Personal Submission

Mount Owen Continued Operations Project

March 2015

Prepared by Dr Kirrily Pollock (B Ag Ec (Hons), PhD) and Donald Woodley

Figure 5.2: Annual and seasonal windroses at SX8 for all data (2009 – 2012) and for the modelling year (2011/2012)

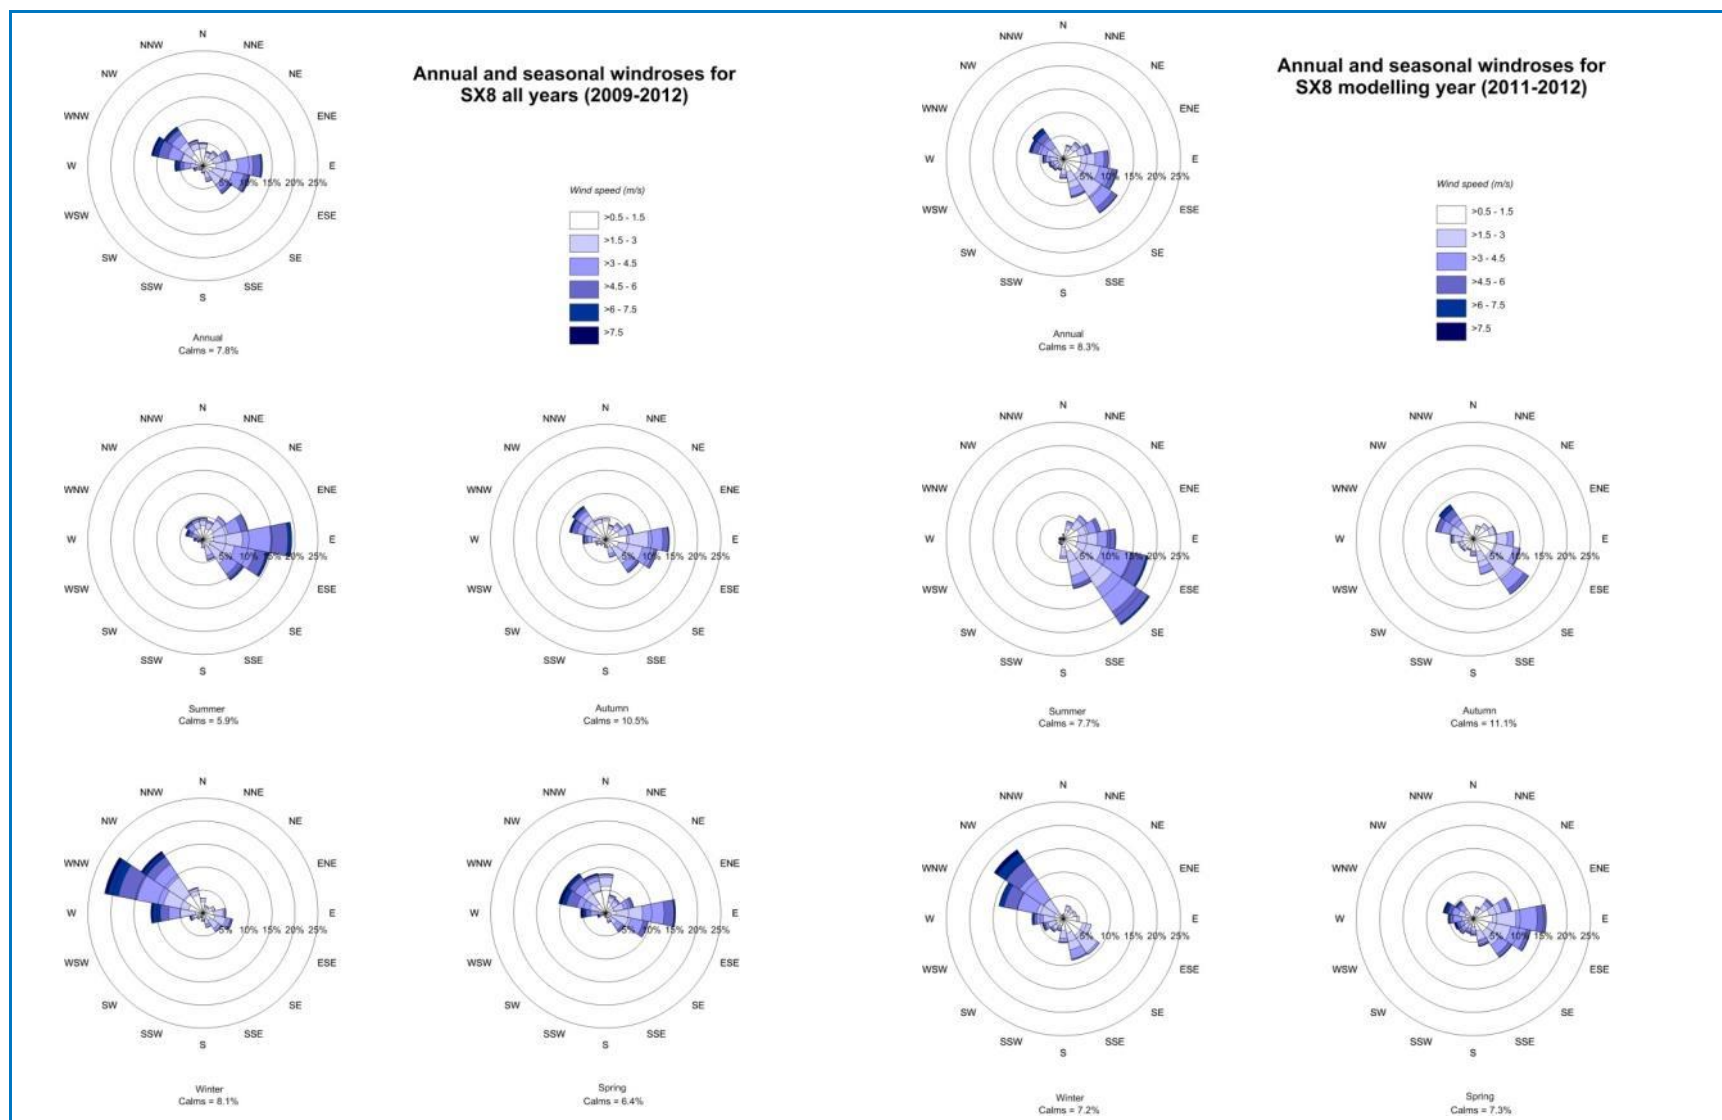
The 2011-12 data selected by Mount Owen for their modelling is broken down into more detail to include the eight half-winds. SX8 data clearly indicates a predominately east to south quadrant instead of the west through north quadrant indicated by the Jerry's Plains historical data (Figure 4). Whilst the SX13 station does contain a higher proportion of the west through north quadrant observations, estimated at around 36 per cent (Figure 5), it is still significantly lower than in the historical Jerry's Plains data.

Whilst the percentage of calms may be similar to the SX8 data, there is little evidence to suggest that the September 2011 to August 2012 wind data that is incorporated into the environmental modelling is representative of historical conditions for the area.

Conclusion: We request that Mount Owen increase the meteorological modelling to the entire three years and eight months they have meteorological data available and ensure the data is in line with historical wind patterns (both direction and speed) for the area.
